# CITY OF ALBUQUERQUE

May 12, 2020

**Re: Chipotle**  
**4331 San Mateo NE**  
**Traffic Circulation Layout**  
Engineer's Stamp 05-11-2020 (G17-D032)

Based upon the information provided in your submittal received 05-12-2020, the above referenced plan cannot be approved for Building Permit until the following comments are addressed:

Easement Area

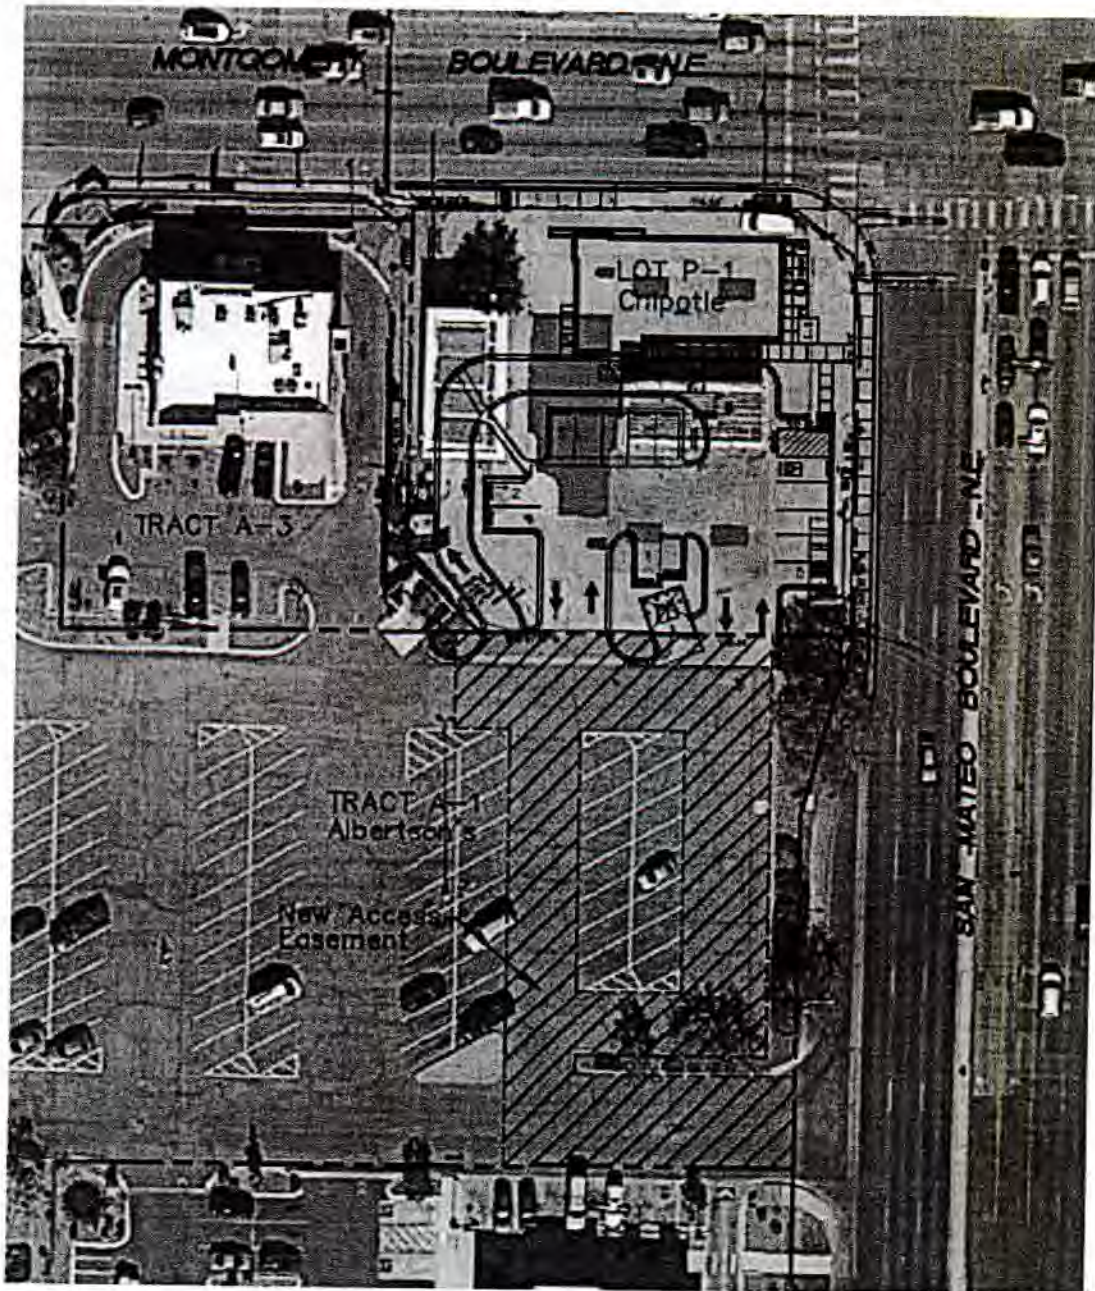
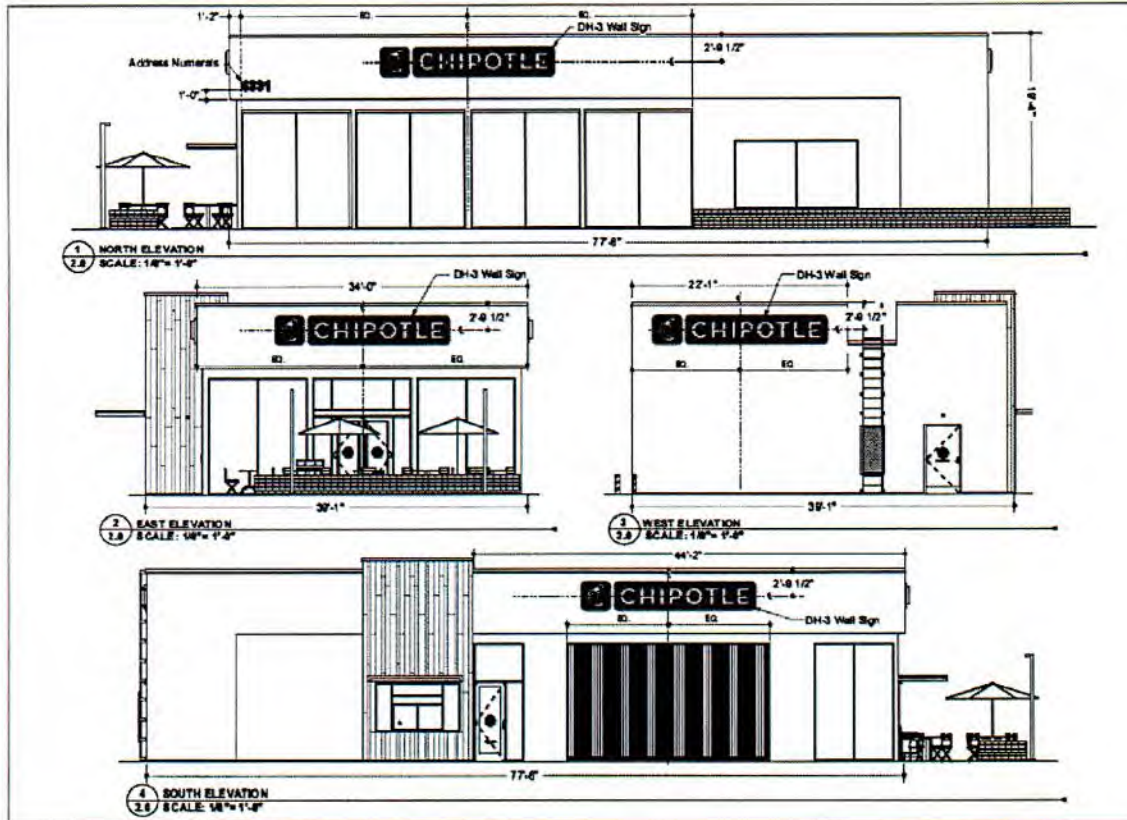
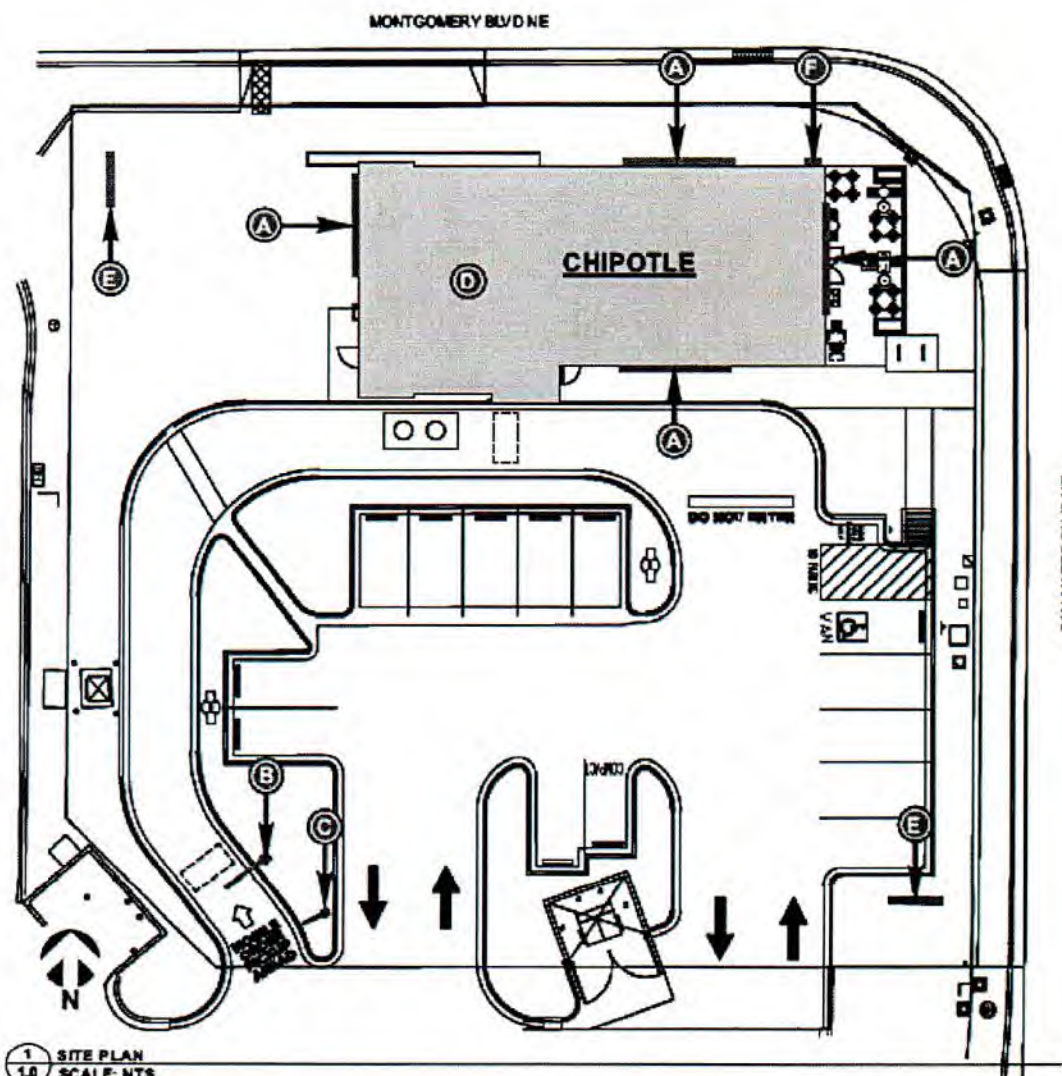
11. Shared Site access (Condition of TCL approval: Easement must be approved and provided for our records): driveways that straddle property lines, or are entirely on one property but are to be used by another property, shall have an

access easement. Please include a copy of your shared access agreement with the adjacent property owner.

Site Plan

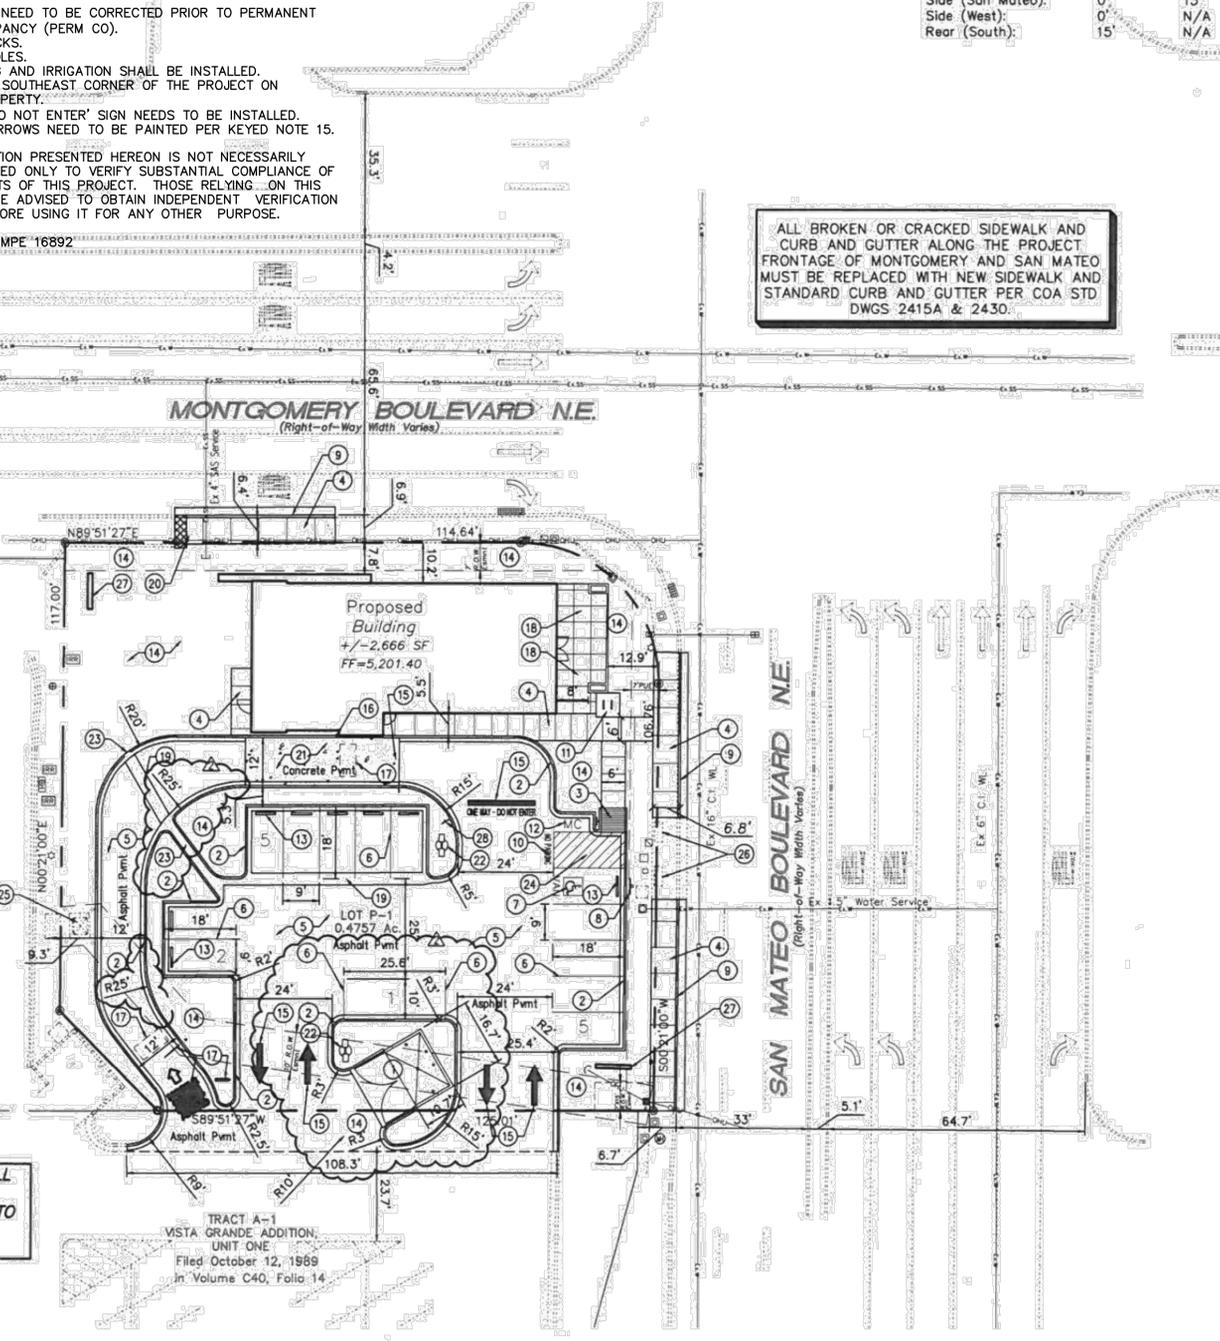
1. Please coordinate all parking calculations with Zoning and list the number of parking spaces required by the zoning as well as the proposed number of parking spaces including bicycle and motorcycle parking.

2. Identify the right of way width, medians, curb cuts, and street widths on Montgomery and San Mateo.
3. ADA curb ramps must be updated to current standards and have truncated domes installed( Corner of Montgomery and San Mateo).

4. Motorcycle parking spaces: Label pavement MC.
5. Per DPM, a 6 ft. wide ADA accessible pedestrian pathway is required from the ADA parking stall access aisles to the building entrances. Please clearly show this pathway and provide details (This includes ramp off access aisle).

6. Existing sidewalk width along Montgomery needs to be provided.
7. Refuse vehicle maneuvering shall be contained on-site. The refuse vehicle shall not back into adjacent property. Provide a copy of refuse approval.

8. The proposed surfaces for the lot will need to be provided on Site Plan.
9. All one-way drives shall have "One Way" and "Do Not Enter" **signage and pavement markings**. Please show detail and location of posted signs and striping (not legible on plans).

10. The minimum drive through lane width is 12 feet with a 25 foot minimum radius (inside edge) for all turns. (A 15 foot radius can be used with an increase in lane width to 14 feet). Please dimension all lane widths and radii.

12. Provide notes showing what work is included and on the work order and the private work on site.
13. Work within the public right of way requires a work order with DRC approved plans.
14. Please add a note on the plan stating "All improvements located in the Right of Way must be included on the work order."
15. Add a note stating "All broken or cracked sidewalk must be replaced with sidewalk and curb & gutter." A build note must be provided referring to the appropriate City Standard drawing.
16. Some of the proposed infrastructure is outside of property line. Please address issue(south).
17. Keyes Notes: Please reference sheet C400 instead of Arch. Site Plan for any and all details needed.
